Application No: BR/200/25/HH
Site Address: 186 Aldwick Road Bognor Regis PO21 2YQ
Description of works: Detached double garage with dormer.

OBJECTION - Members object to this application for the following reasons:

Proposed South Elevation
1 : 100

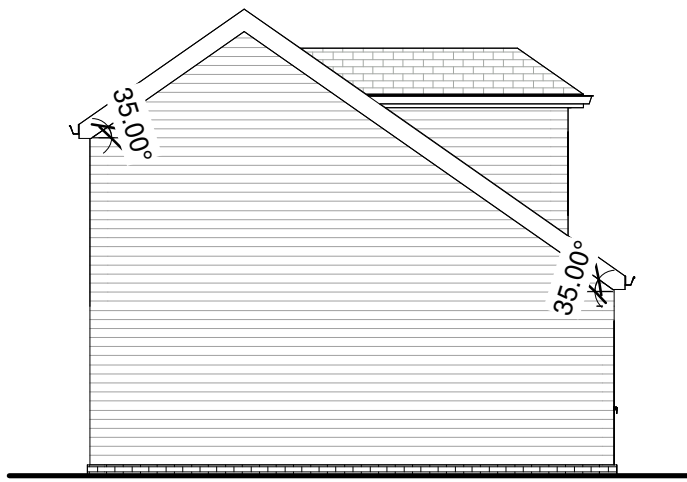
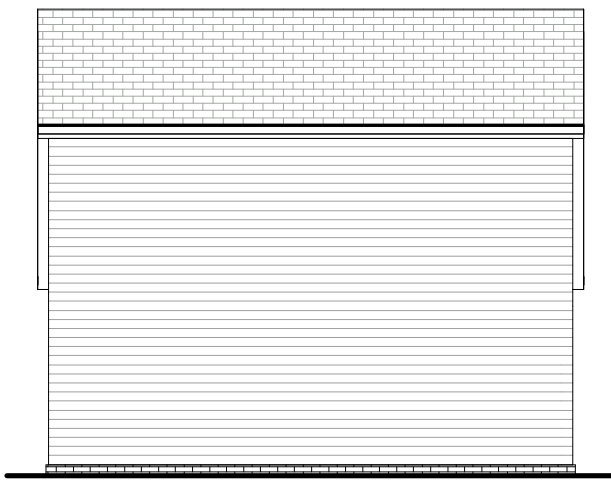
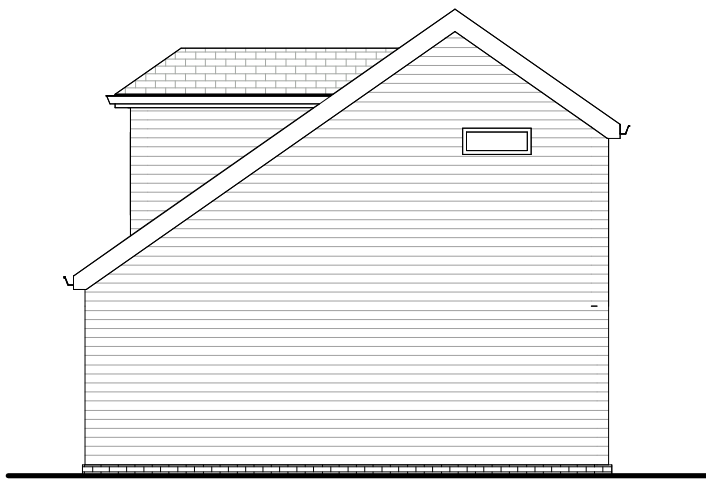
The proposed garage and office, positioned prominently in front of the dwelling, are considered excessively large, visually intrusive, and wholly out of keeping with the established character of Aldwick Road, where open frontages and dwellings set well back create a spacious streetscape. The development would dominate the street scene and introduce an incompatible form of built development that conflicts with the prevailing pattern of single detached houses behind landscaped gardens.

The proposed building would be highly visible from Aldwick Road and, due to its scale and position, would detract from the appearance of Aldwick Road, giving the impression of two separate dwellings.

The design fails to respect or complement the character of surrounding dwellings, including the Tudor-style architecture of the host property. The proposal does not demonstrate high-quality or context-appropriate design and therefore does not meet the expectations of the Local Plan or NPPF Paragraph 134.

Block Plan

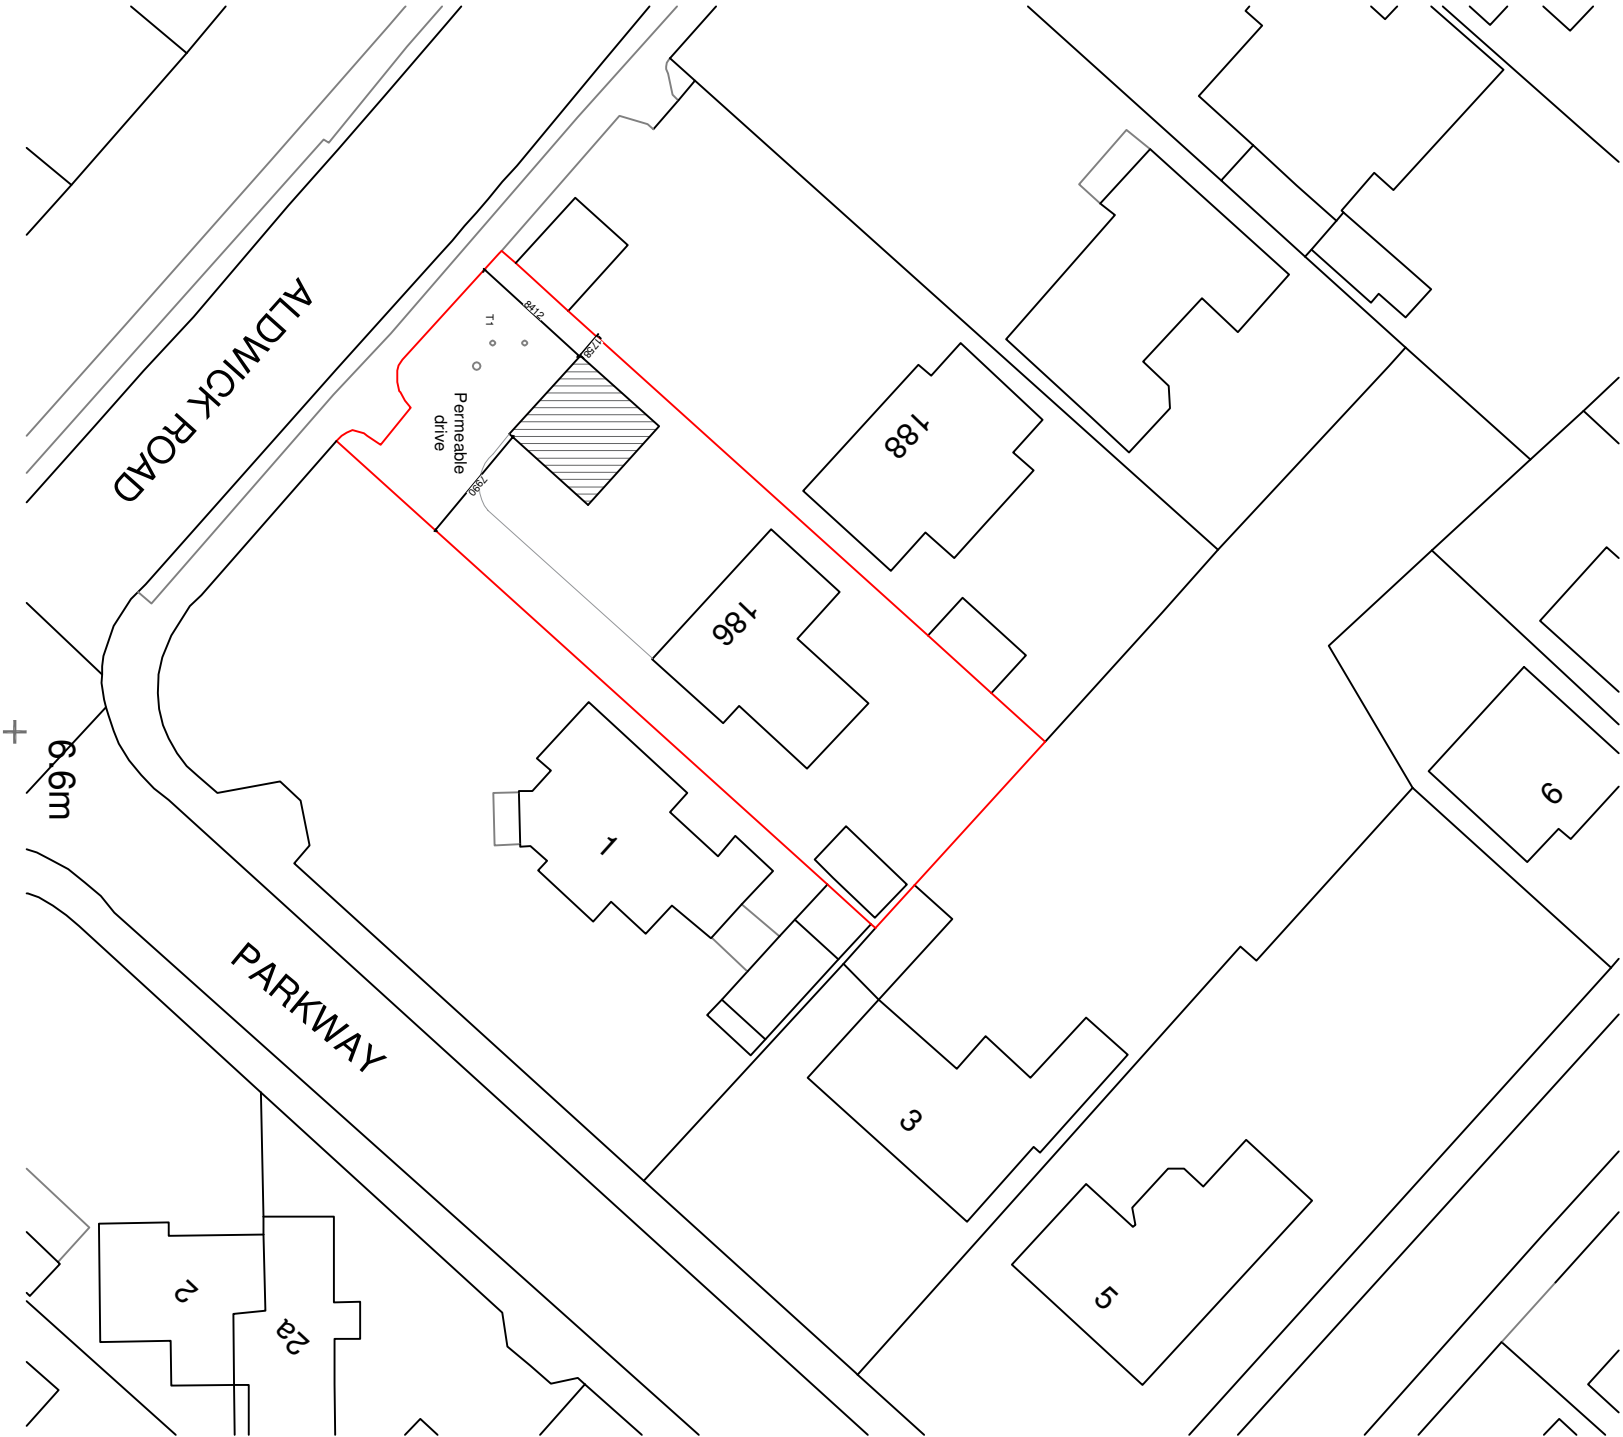
The scale and siting of the proposed structure would result in an over-dominant and overbearing impact on neighbouring properties, reducing light, affecting outlook, and creating a physical barrier at odds with the open character of the area. Concerns are also raised regarding intensified activity associated with the enlarged hardstanding and constrained manoeuvring space, which could lead to vehicles reversing onto Aldwick Road, raising highway safety issues. The inclusion of WC facilities and potential for further installation suggests the building could be used more intensively than a simple home office.

By projecting forward of the existing dwelling and garage, the proposal disrupts the established building line and undermines the consistent rhythm of properties along Aldwick Road. Members consider that approval would set an undesirable precedent for similar forward-built structures, further eroding the character of the area.
